Engineers Comments Regarding Surface Water Drainage

Application Reference:	Y/37/25/DOC	Reviewer Reference:	ADC/EXT4
Planning Officer:	Hebe Smith	Date of Review:	21/08/2025
Site Name:	18 West View Drive Yapton BN18 0JR		
Application Description:	Approval of details reserved by condition imposed under reference Y/56/24/HH relating to condition number 3 - surface water drainage scheme.		
Assessment Number:	1 of 2

Client Mr & Mrs Roberts-Davies
Drawing Title Ditch & Headwall Details

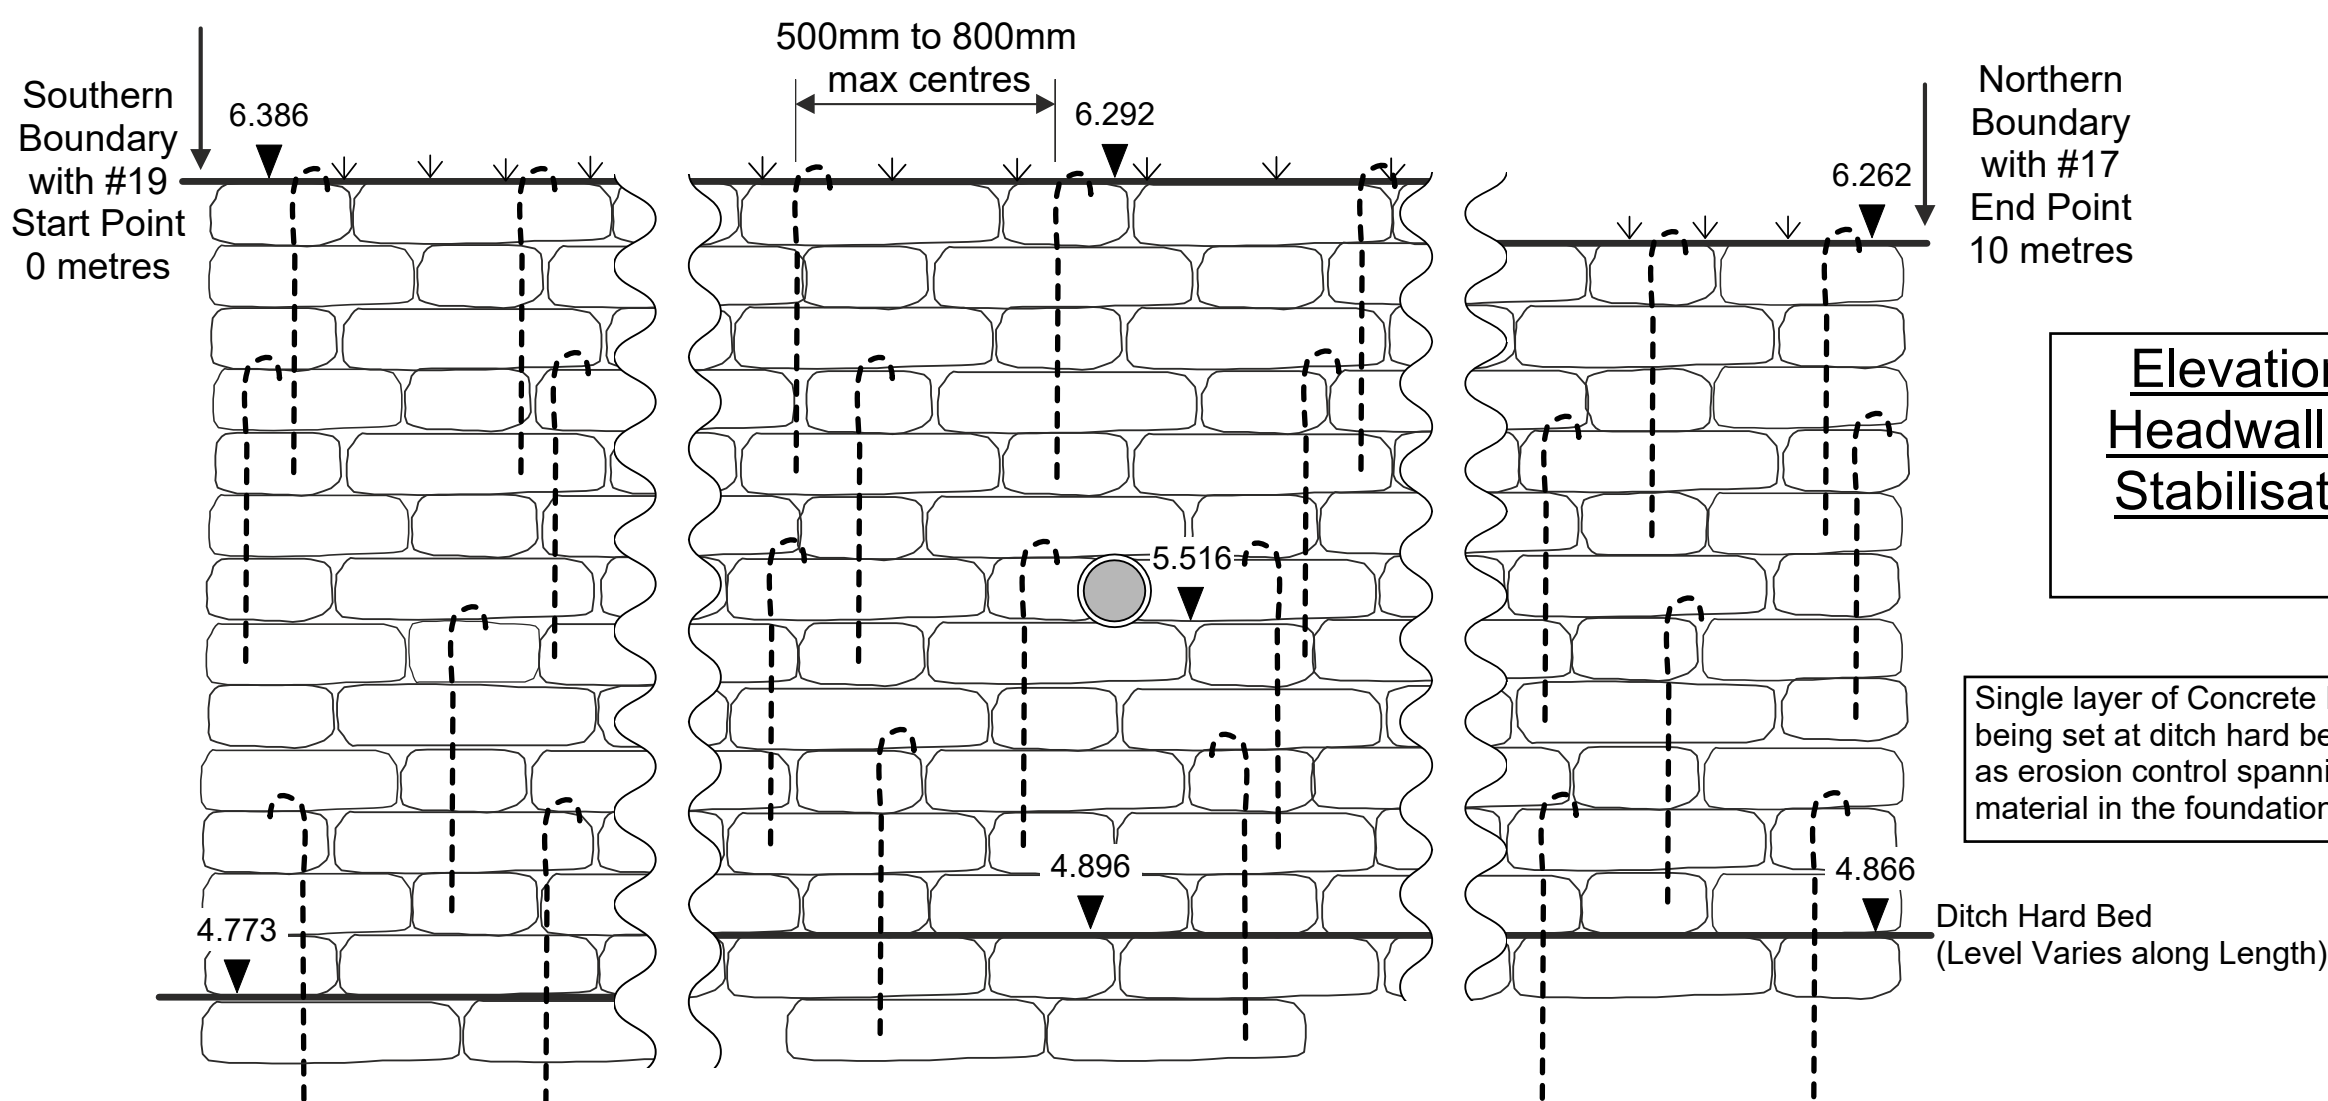
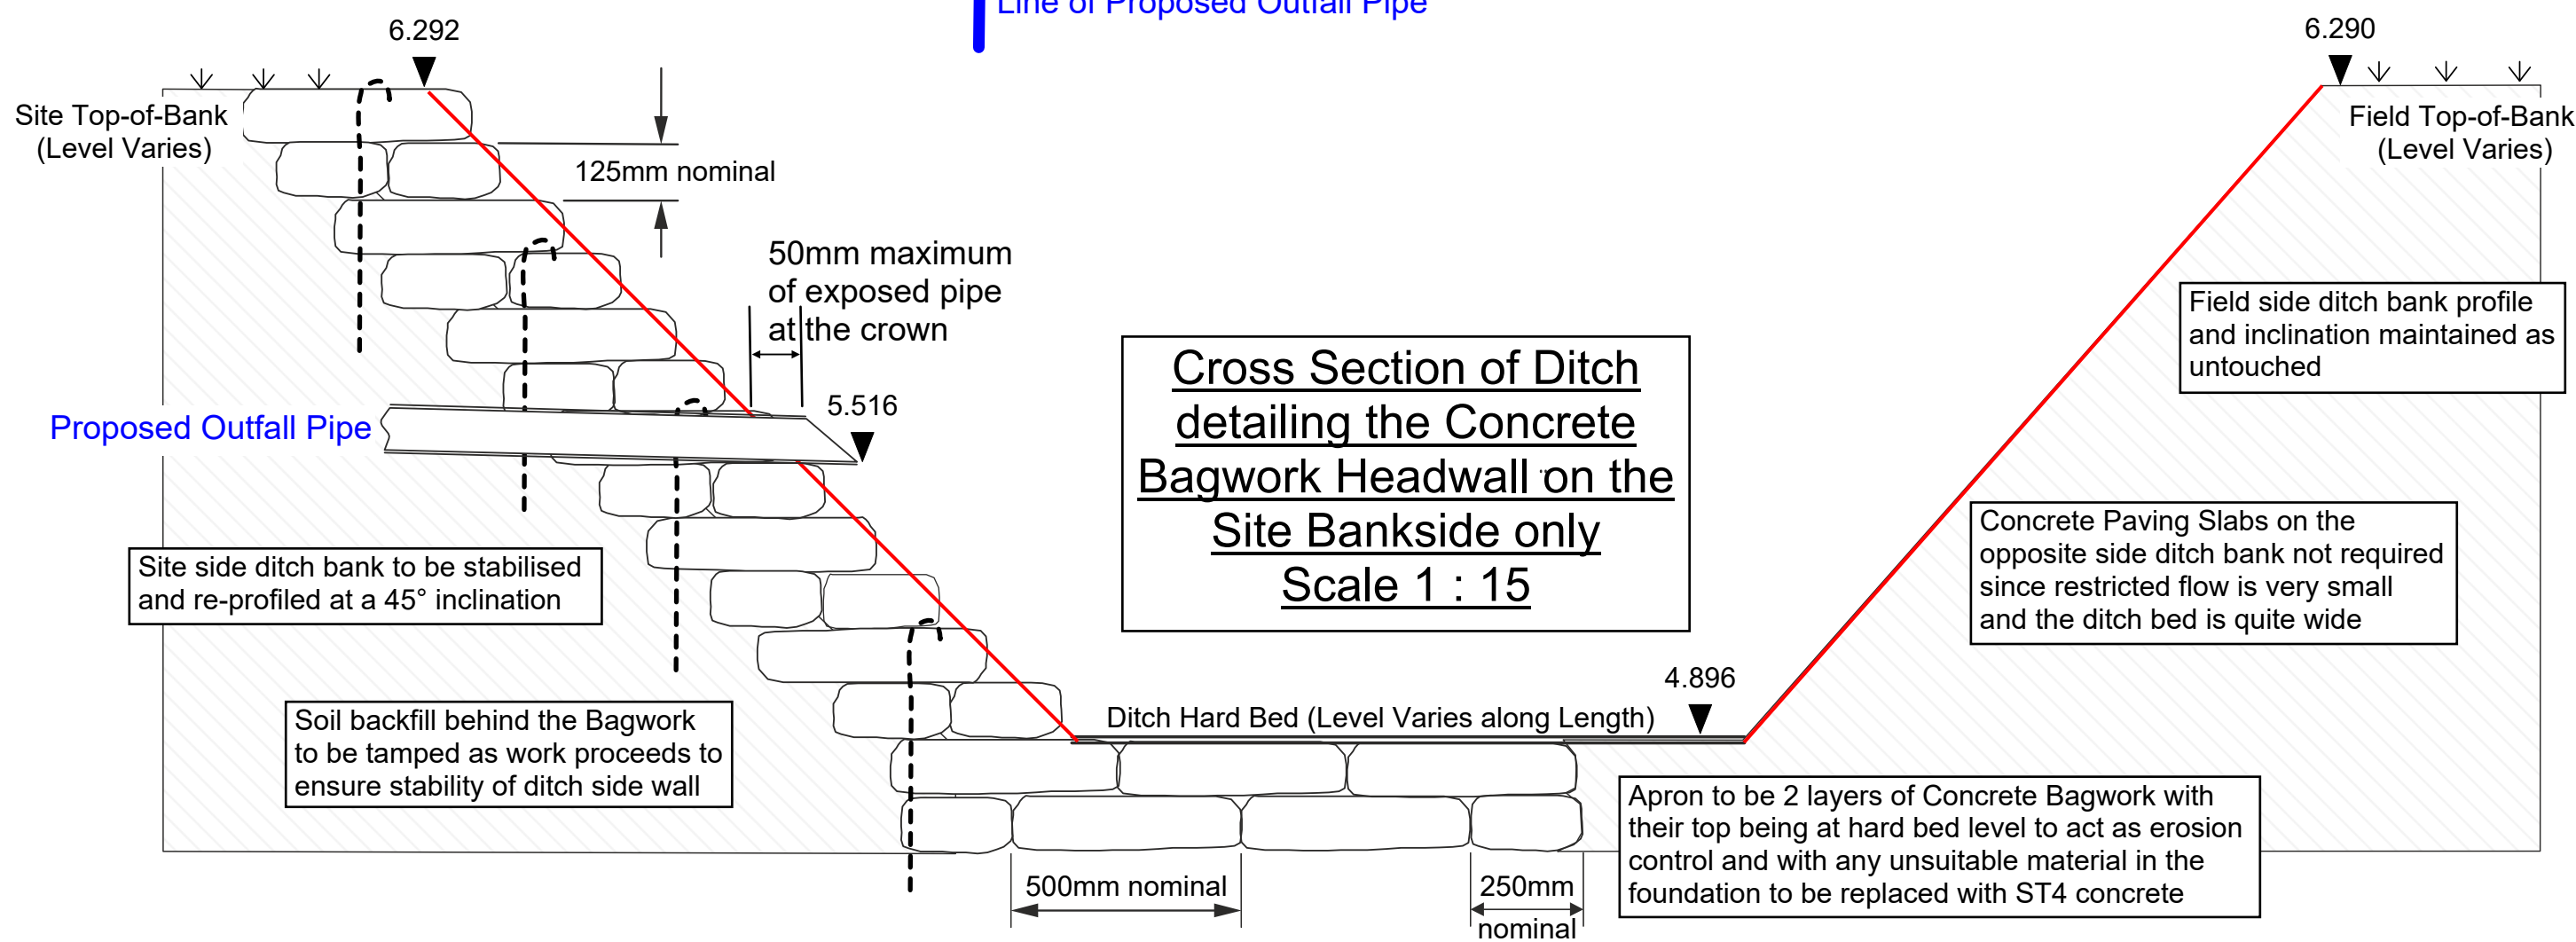
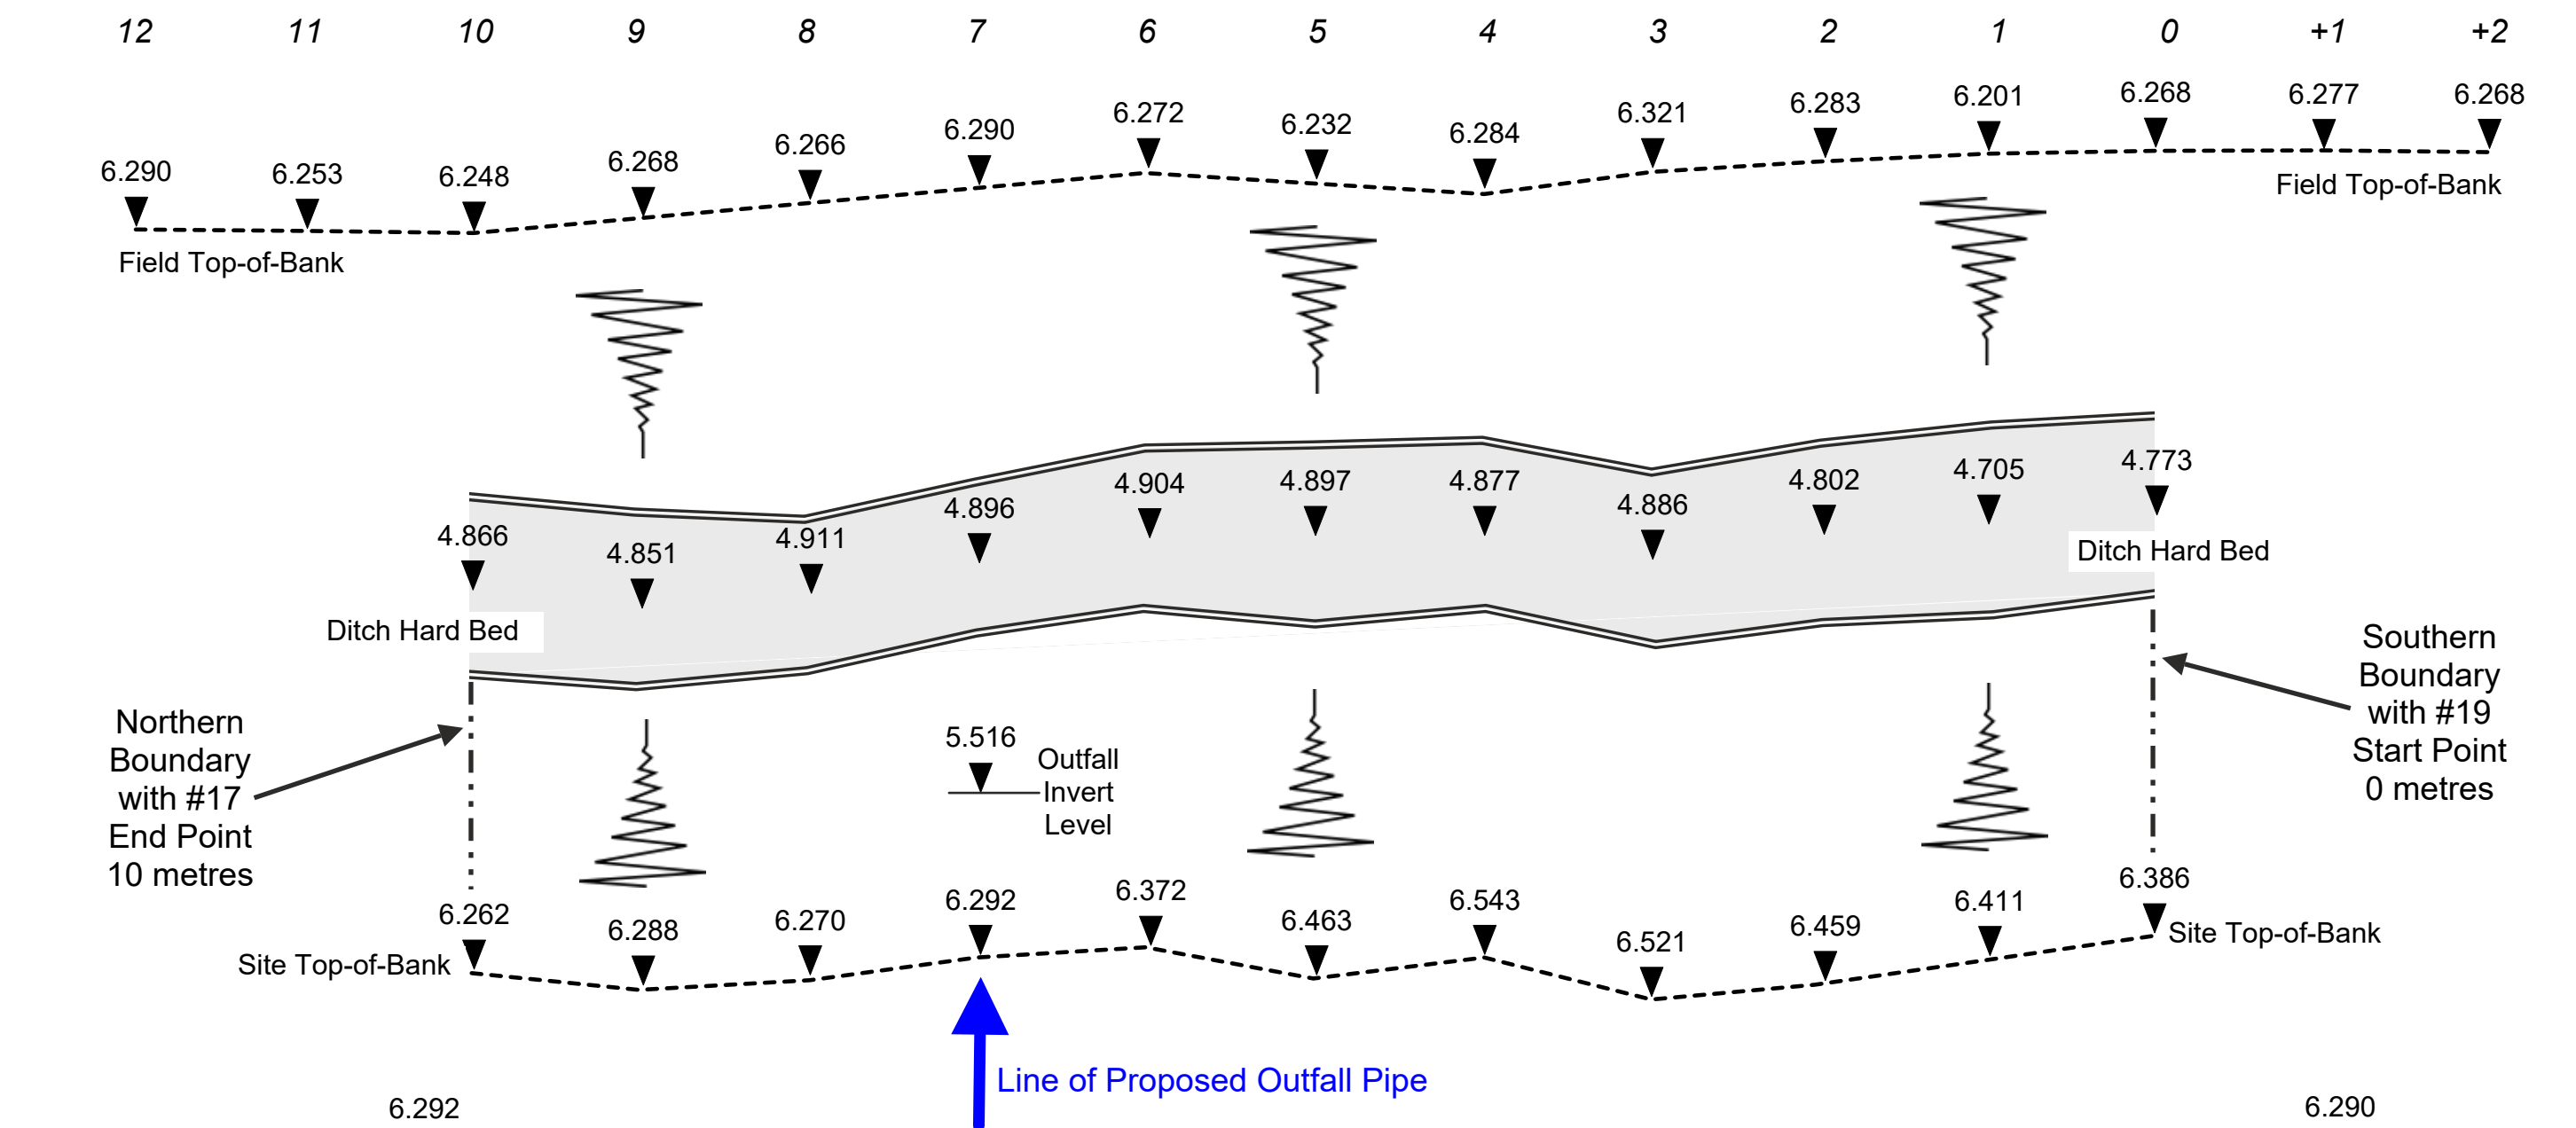
3.	The proposed headwall outfall and works appear to lie outside of the application boundary and potentially outside the extent of ownership of the applicant. Clarification on the extent of proposed works for the construction of the new headwall will be required including either confirmation of land ownership or 3 rd party permissions if application. Please note that the construction of the new headwall will require a and Ordinary Watercourse Consent from West Sussex County Council

Client
Mr & Mrs Roberts-Davies
Drawing Title
Surface Water
Drainage Layout

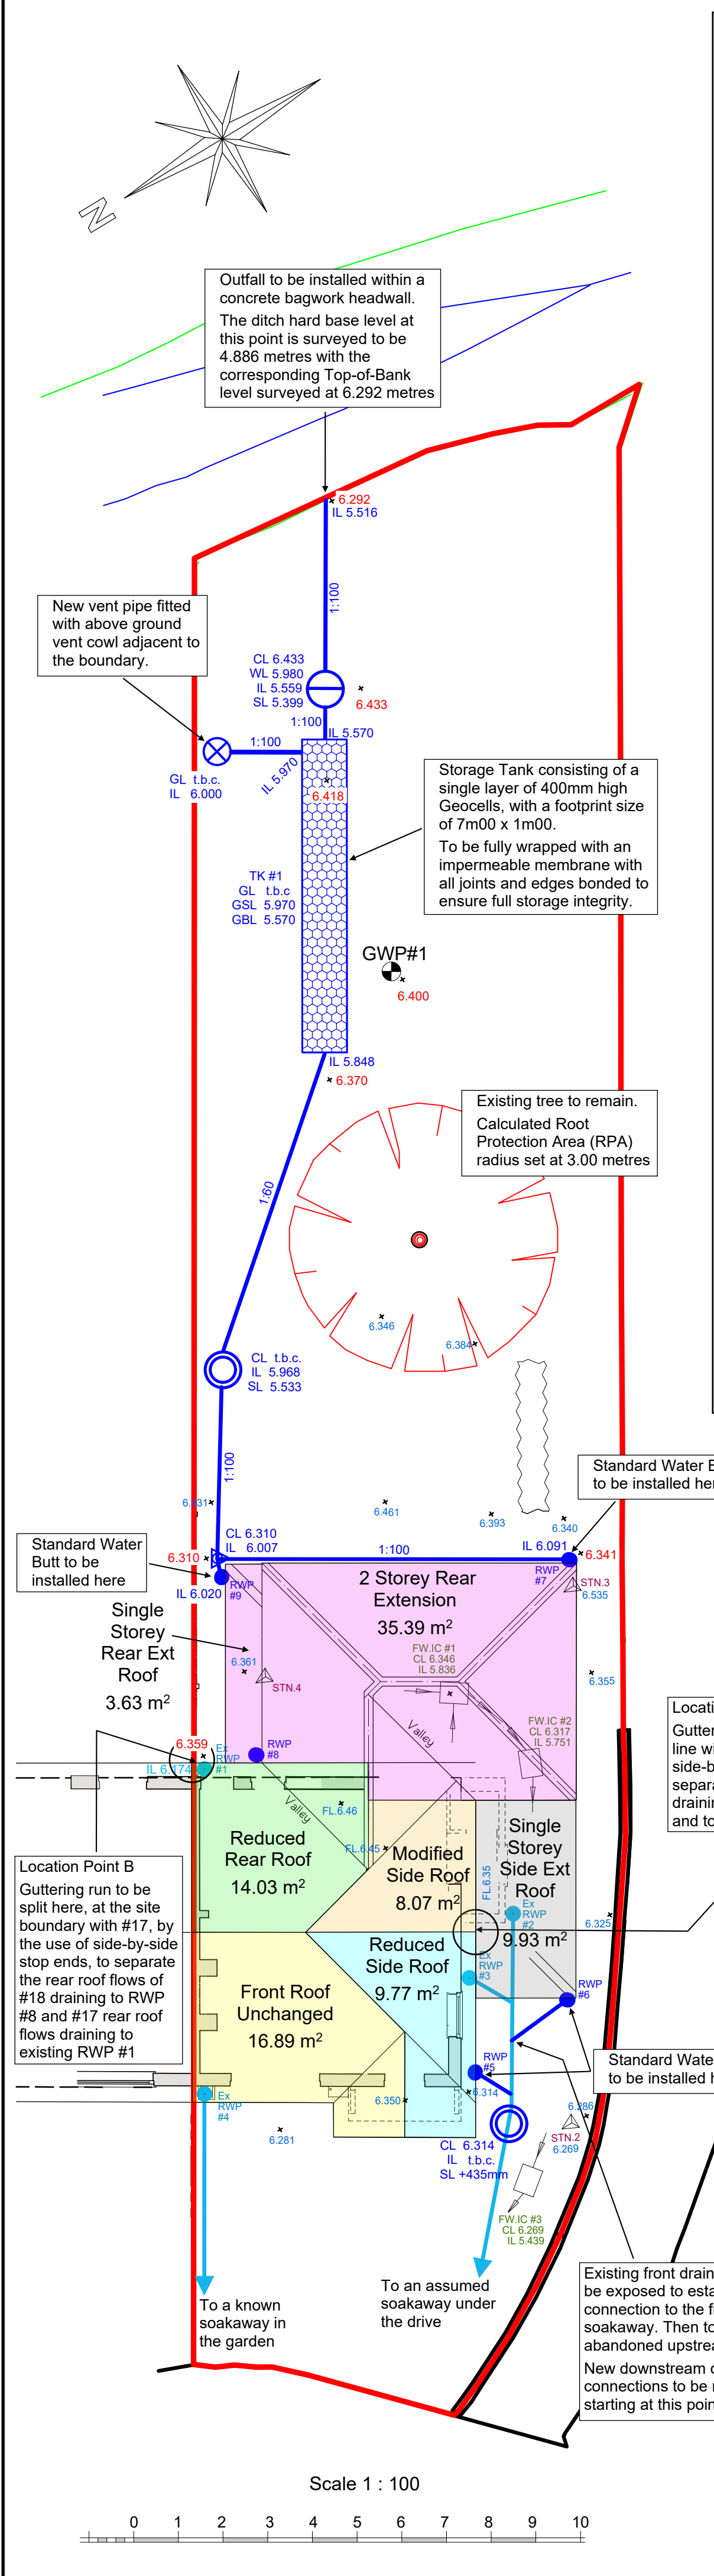
Comment Number					
1.	Front roof areas noted to drain to an “assumed” soakaway. This needs to be investigated further and onsite assessment through testing to confirm that the existing soakaways can cater for the peak design storm events if looking to reuse.

2.	The current drainage layout, includes several assumptions and caveats due to unknown level information. Some of these are critical to the function of the proposed surface water drainage and thus need to be investigated and confirmed

4.	The depth of drainage at the rear elevation appears too shallow, with inadequate cover to the pipework. Further details should be provided on this arrangement and potentially re-look at the gradient and depth of pipework leading back from the attenuation tank

5.	Please provide clarification on how the surcharge outfall has been modelled.
